RE: BL-16-00006 Wallace

Subject: BL-16-00006 Wallace

Could you please review this application and submit comments for the decision. Control Click on the hyperlink above (or go to the attachment tab in EDEN). Comment period for this application ends on **6/25/2016**.

**PART OF THE NORTHEAST QUARTER OF SECTION 31,
TOWNSHIP 17 NORTH, RANGE 19 EAST, W.M.**

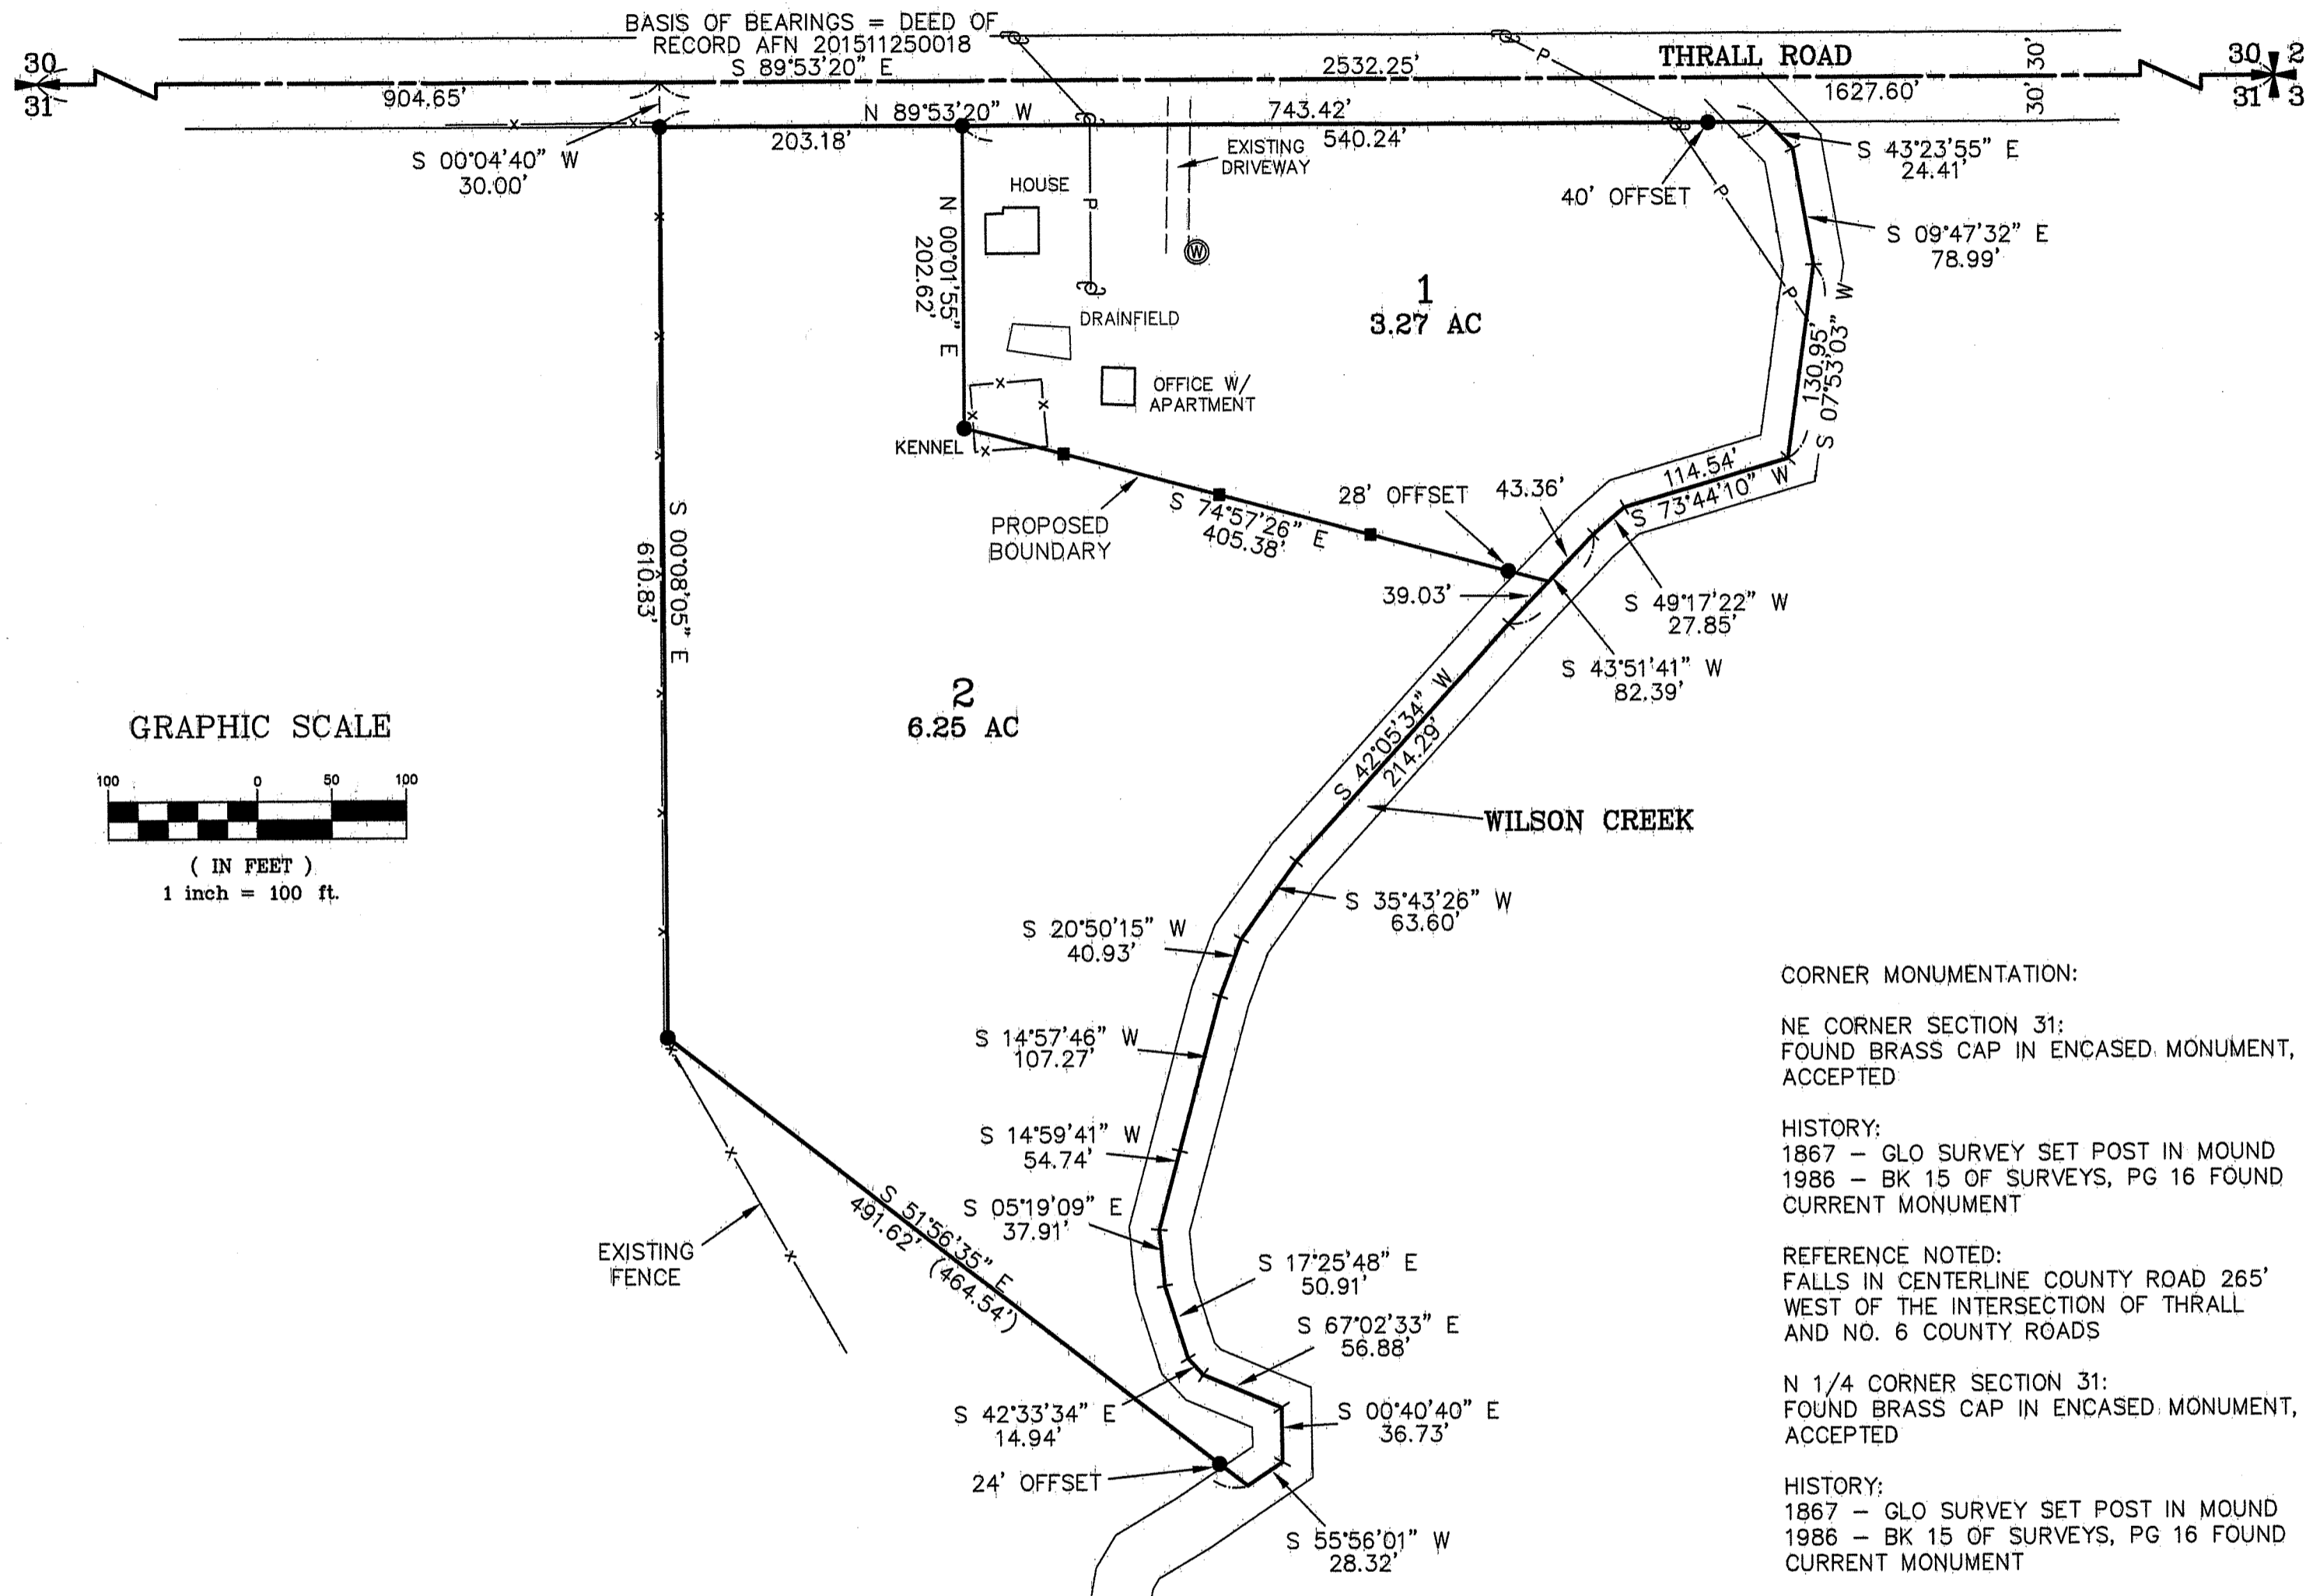
Parcel 640333 will have an existing house and an office with an apartment in it once the BL is approved. This represents two dwelling units. Parcel 920333 will need to drill a separate well unless the existing well is converted to a Group B well. A well with 3 or more dwelling units on it is considered a public well.
